Application number: 2024/91108	
What is the application for?:	Erection of 4 residential garages to serve nos 1-4 with associated external work
Address of the site or building:	Land at 1-4, Old Engine Close, Mirfield, WF14 0JF
Postcode:	WF14 8NA

Type of comment: An objection	
Do you wish your comments to be published on the website anonymously?	No

REF: 2024/91108

Project.	NEW GARAGES LAND AT OLD ENGINE CLOSE, MIRFIELD, KIRKLEES, WF14-0JF	Client.	R. HETHERINGTON
Drawing Title.	PROPOSAL GARAGE PLANS & ELEVATIONS	Date.	APRIL 2024
Ref.	105/43	Scale.	AS INDICATED
Dwg. No.	03	Rev.

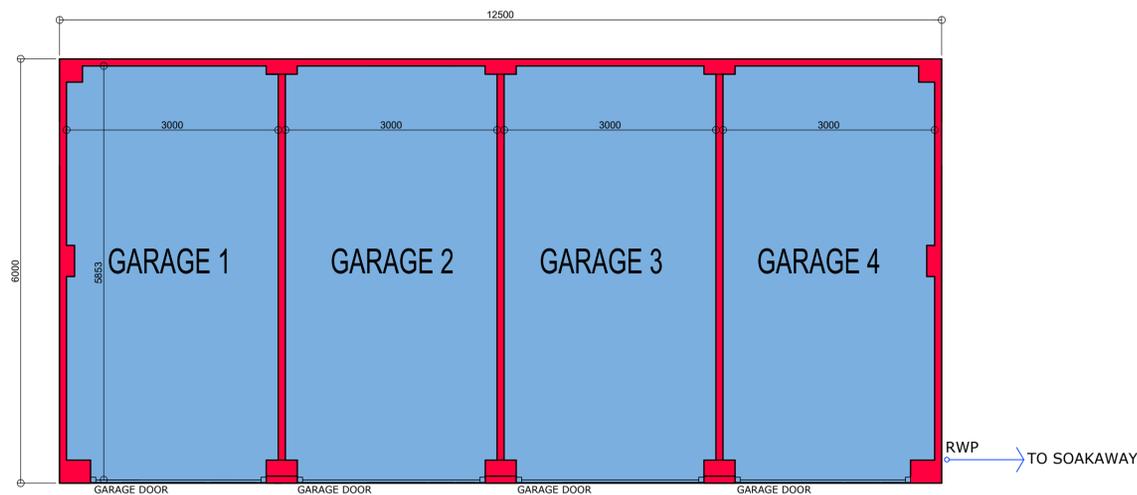
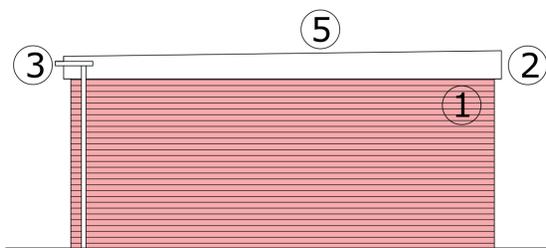
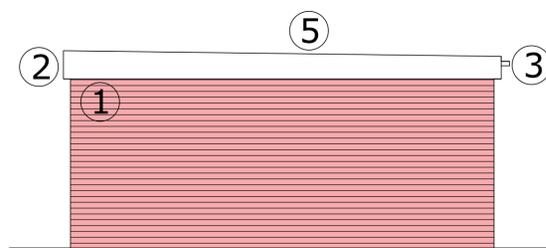
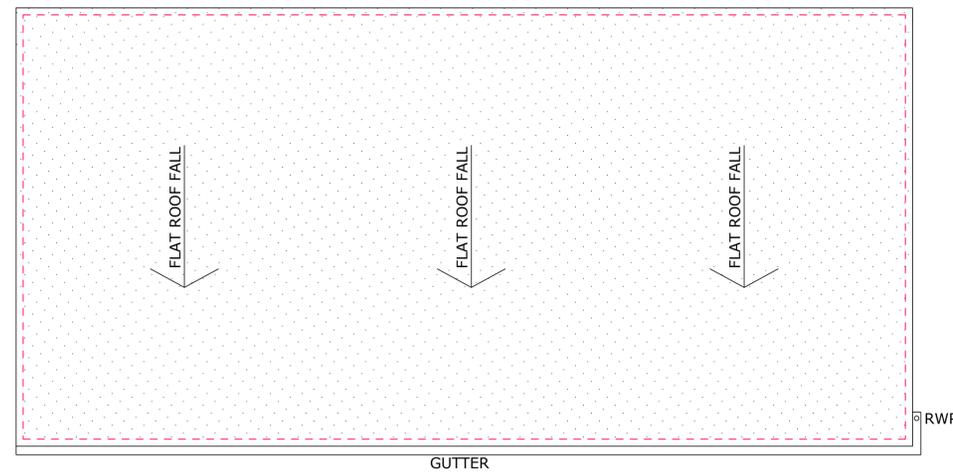
Fundamentally we understand that the proposed plans encroach onto our land, as identified by our HM Land Registry document (this is available upon request). Those accessing the garages would also be driving across our land to gain access.

The garages will also cause a reduction of our turning space and impact on our manoeuvrability on our own driveway.

Because of their location, and proximity to numbers 9-11 in particular, our privacy will be severely compromised due to the proximity of the garages to our home.

This does not comply with policy LP24 of the Local Plan, with the form, scale and layout of the proposal not reflecting the area, and with the natural environment being impaired. The garages would fail to sympathetically relate to the existing development and will eliminate the only green space on Old Engine Close. This lack of biodiversity, coupled with recent developments in the local area, including at the back of our home, have already reduced green space and is becoming a concern. This development will be immensely unsightly, ugly and overbearing, taking up valuable green space.
